From: Amanda Scholes on behalf of Planning.Responses
Sent: 11 June 2020 08:31
To: Planning Scanning
Subject: FW: Planning Consultation on M/28/20/DOC

Engineers comments;

The level of detail supplied is currently insufficient to enable the discharge of conditions 11, 13 or 14.

Site: YAPTON POULTRY FARM
Project: MIDDLETON RESIDENTIAL
Date: 01/07/2020
Drawing: SITE VISIT DISCUSSION
APPENDIX 02

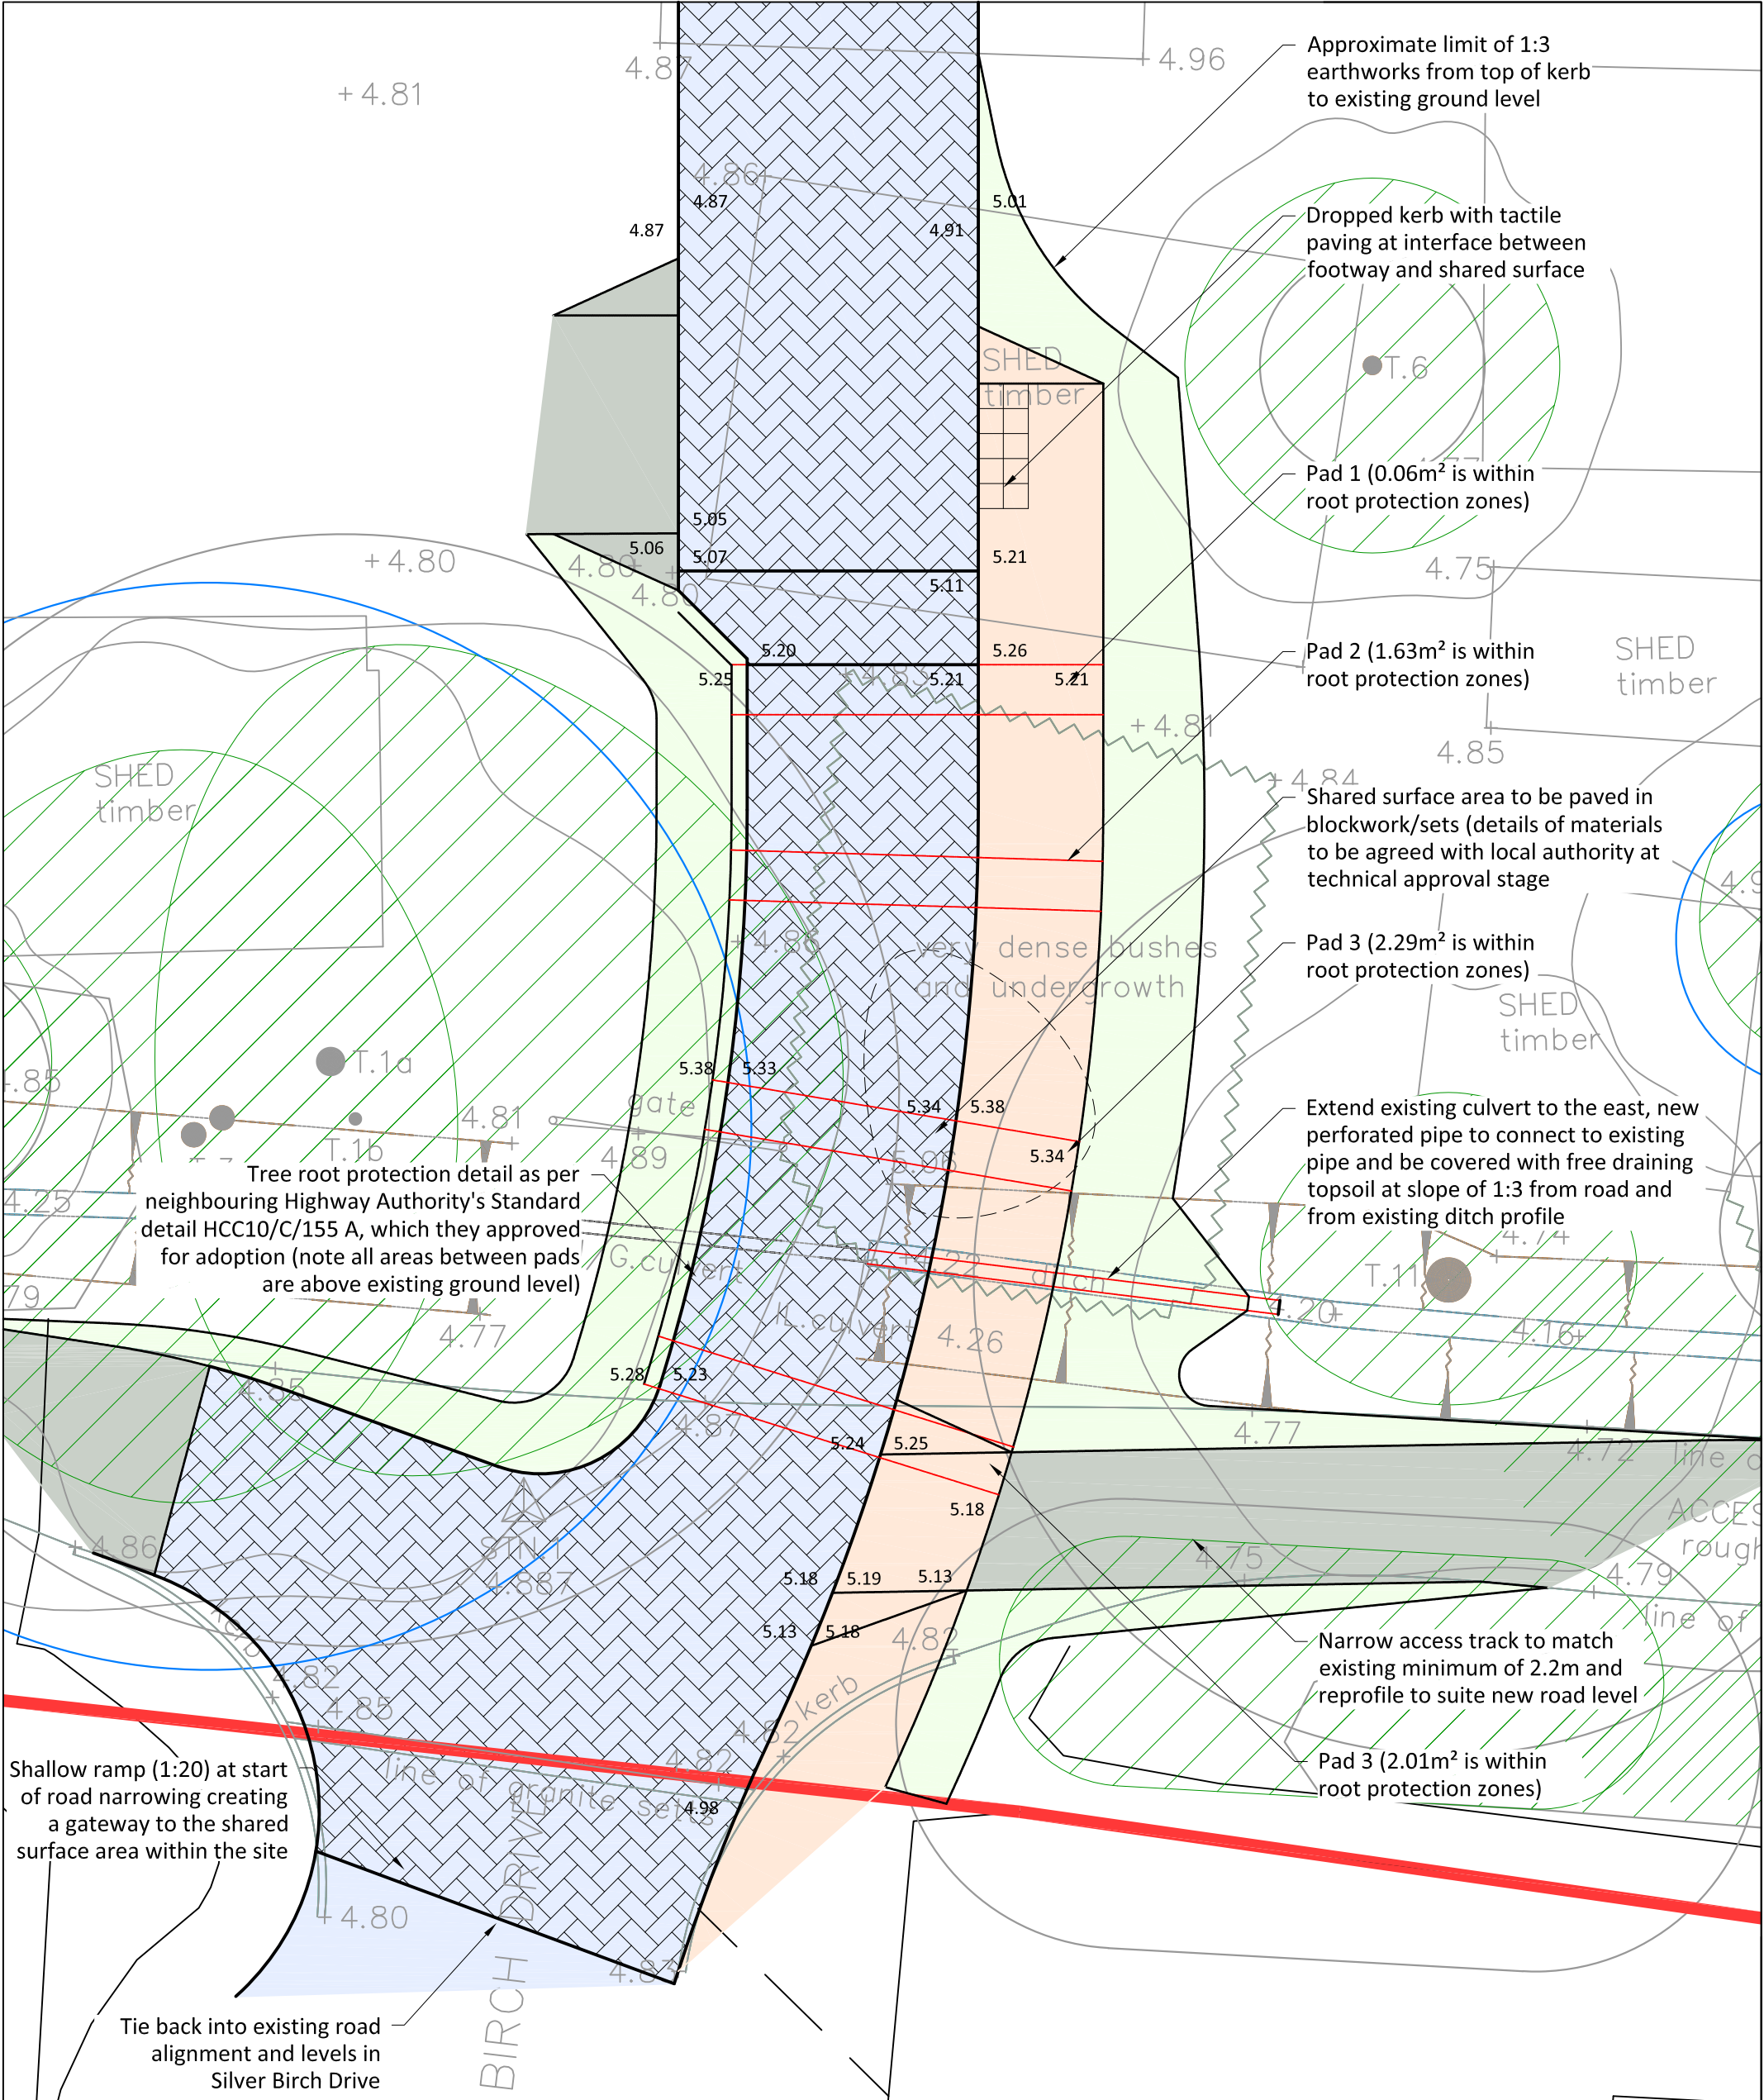
Regarding the ditches on the southern boundary, it is very likely that these will need improvements and I suggest a meeting takes place on site to look at these. Land Drainage Consent will be required for any alterations to them, including culverting and any discharge structures. This will all need to be fully detailed on the drawings.

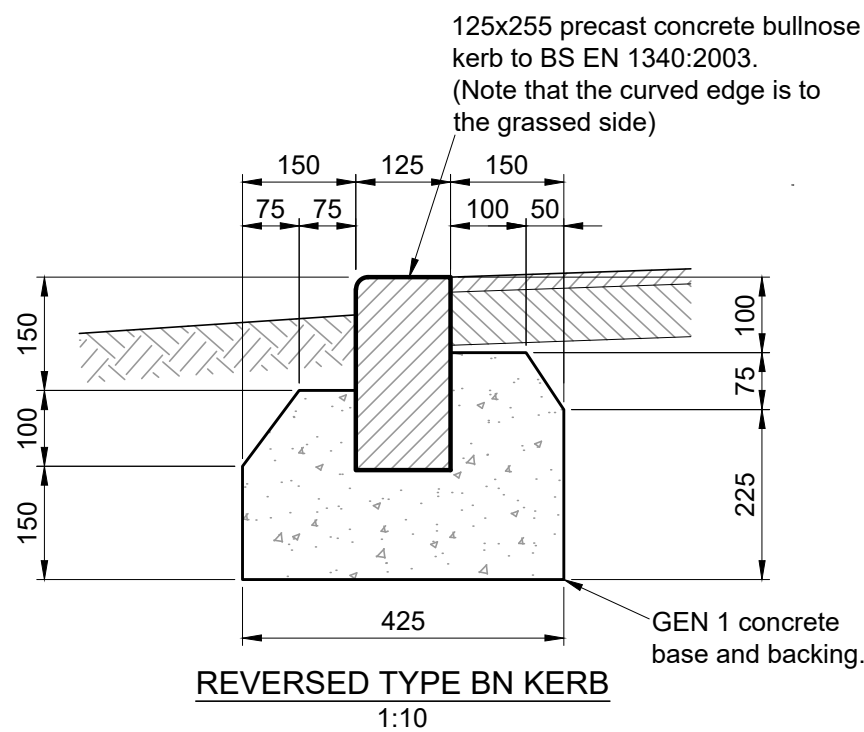
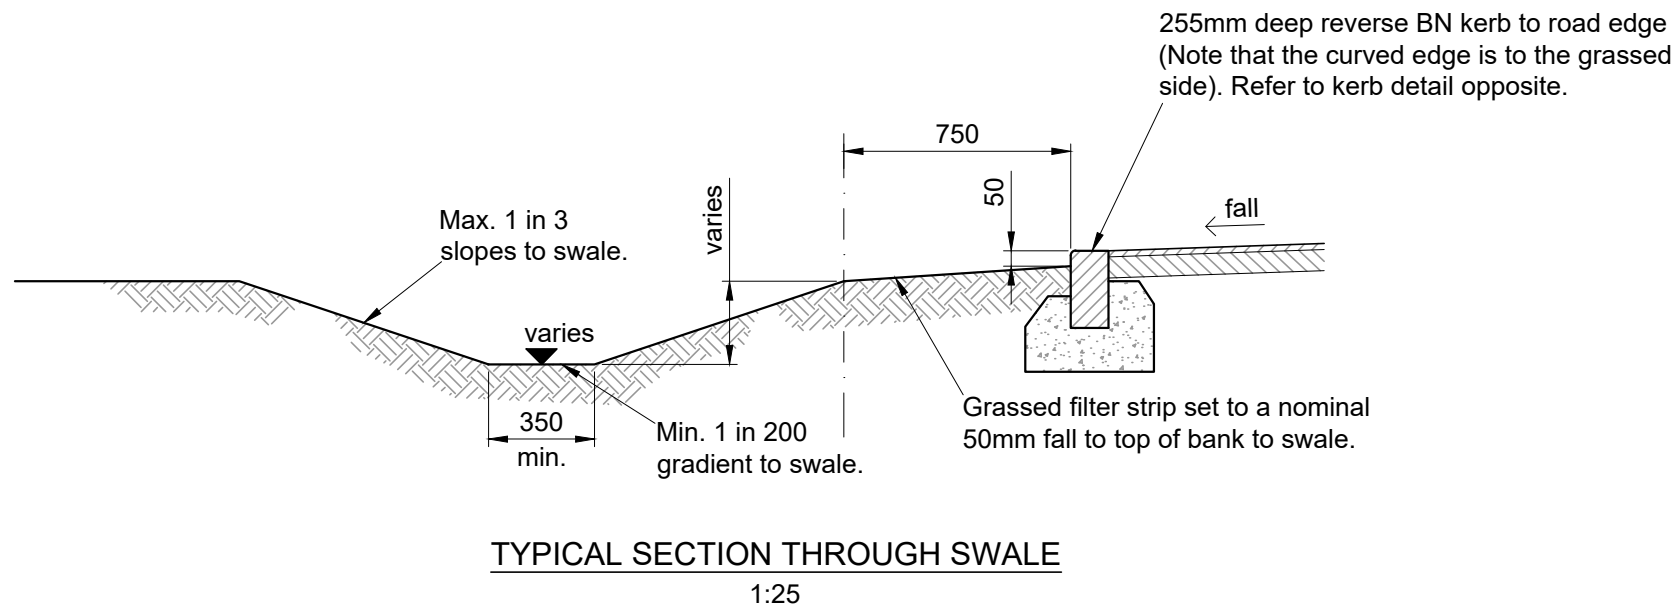
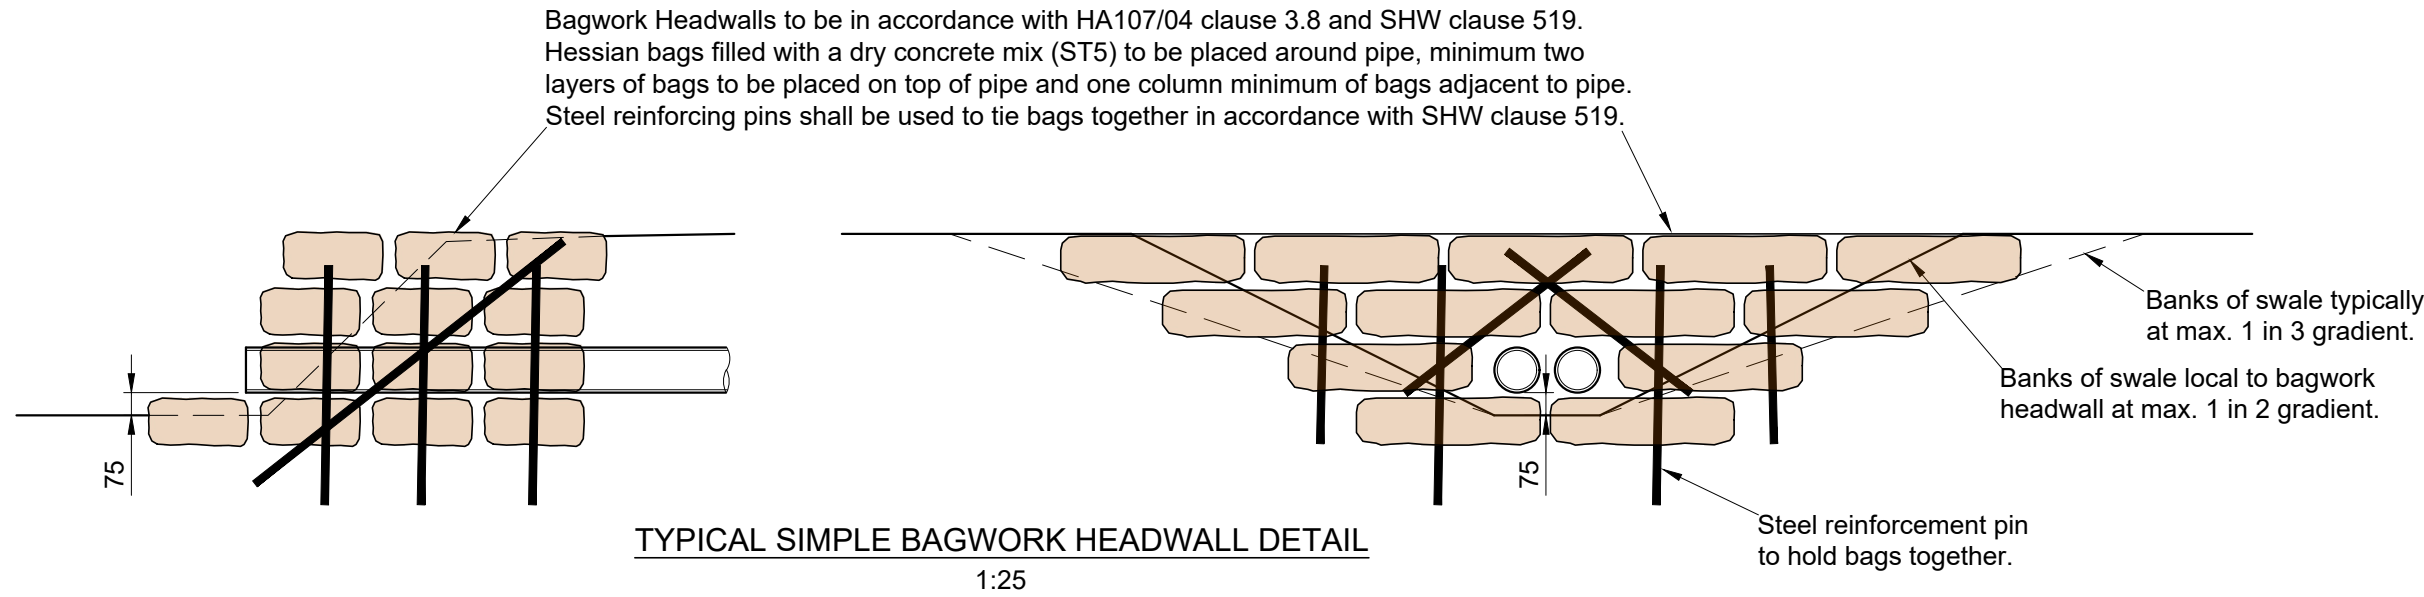
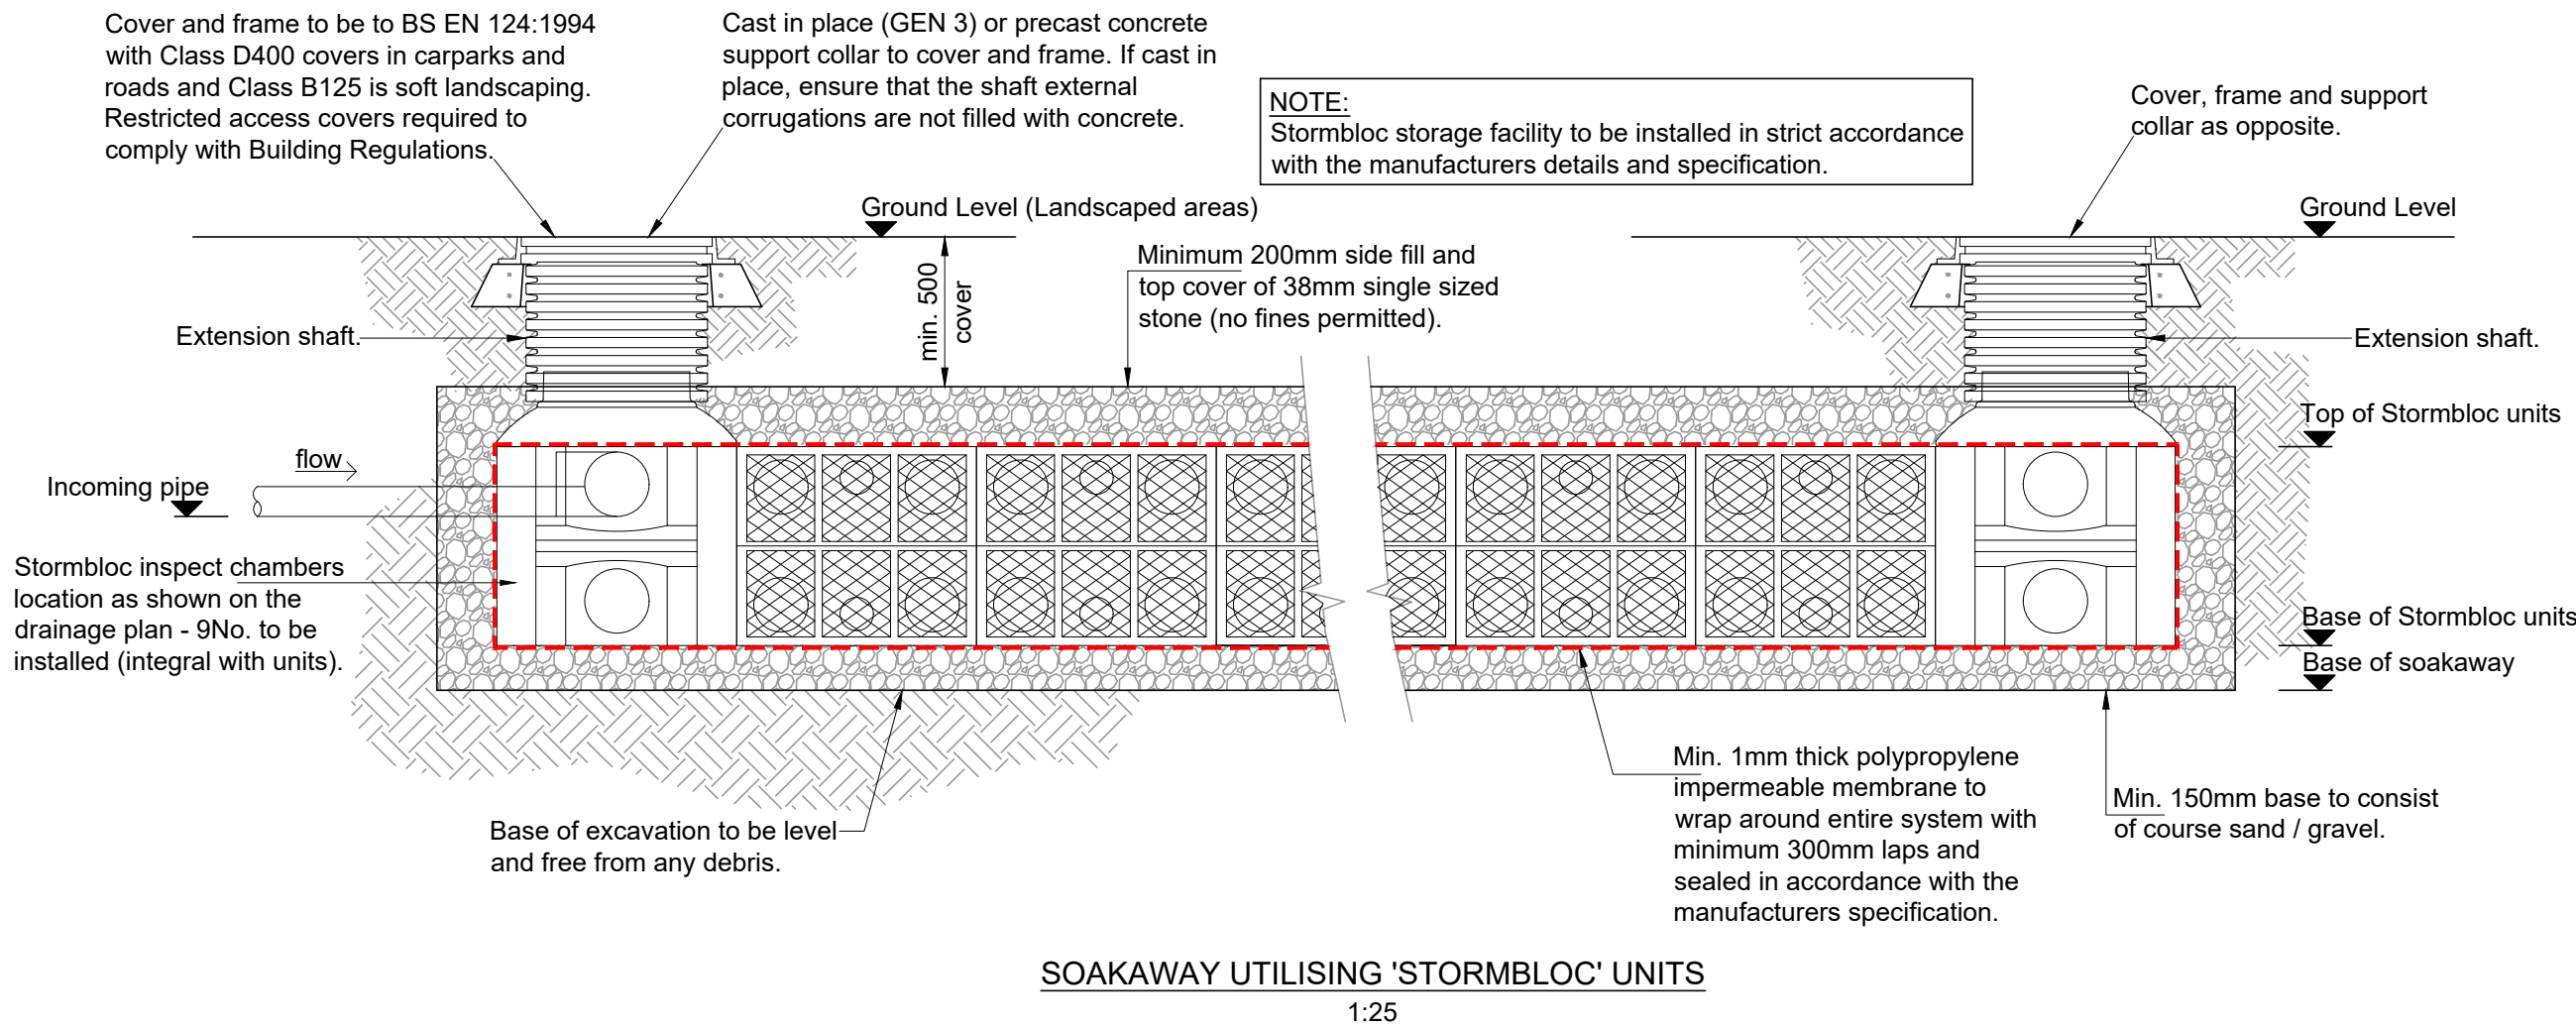
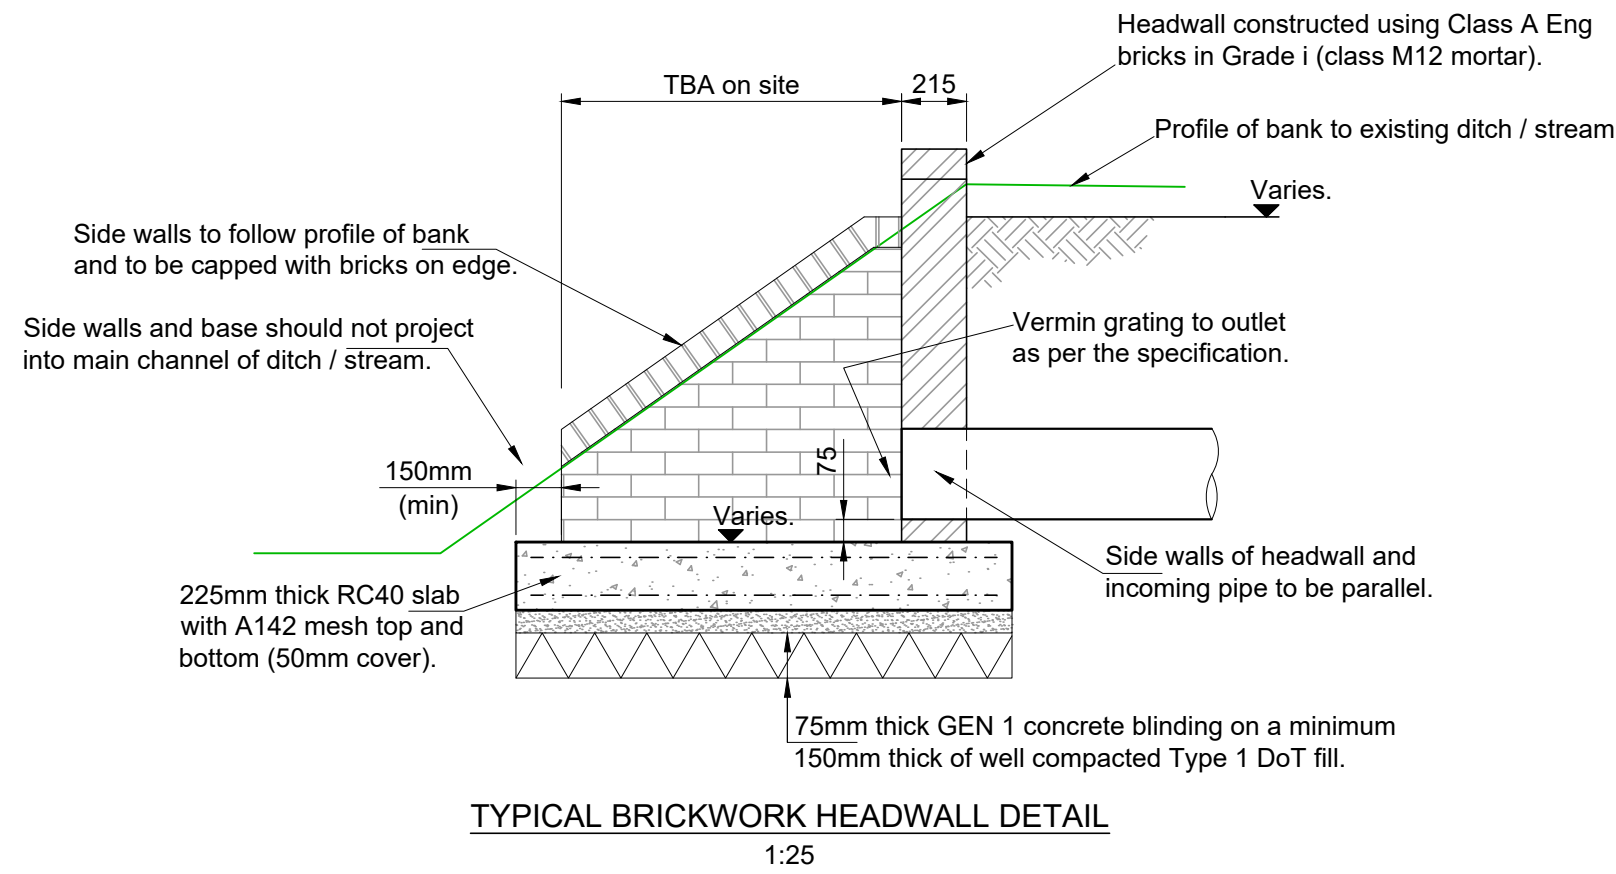
Once we have agreed the scheme principles, fully detailed plans will be required to include pipe/structure, cover levels/invert levels/base levels/diameters/gradients, etc, along with fully detailed construction drawings for all drainage elements. Please note that open suds features should be employed where possible. The current arrangement of crates is currently not desirable, since they have been arranged in manner as to use almost every piece of available space outside the root protection zones (zones will need to be confirmed), rather than achieve a more practical layout whereby membranes can be wrapped around the crates in a more suitable manner ie. reduce the number of corners. Please note that our tree officer will need to be involved in discussions in this respect due to protect the trees and the crates. Permeable paving will need to be employed where ever possible.
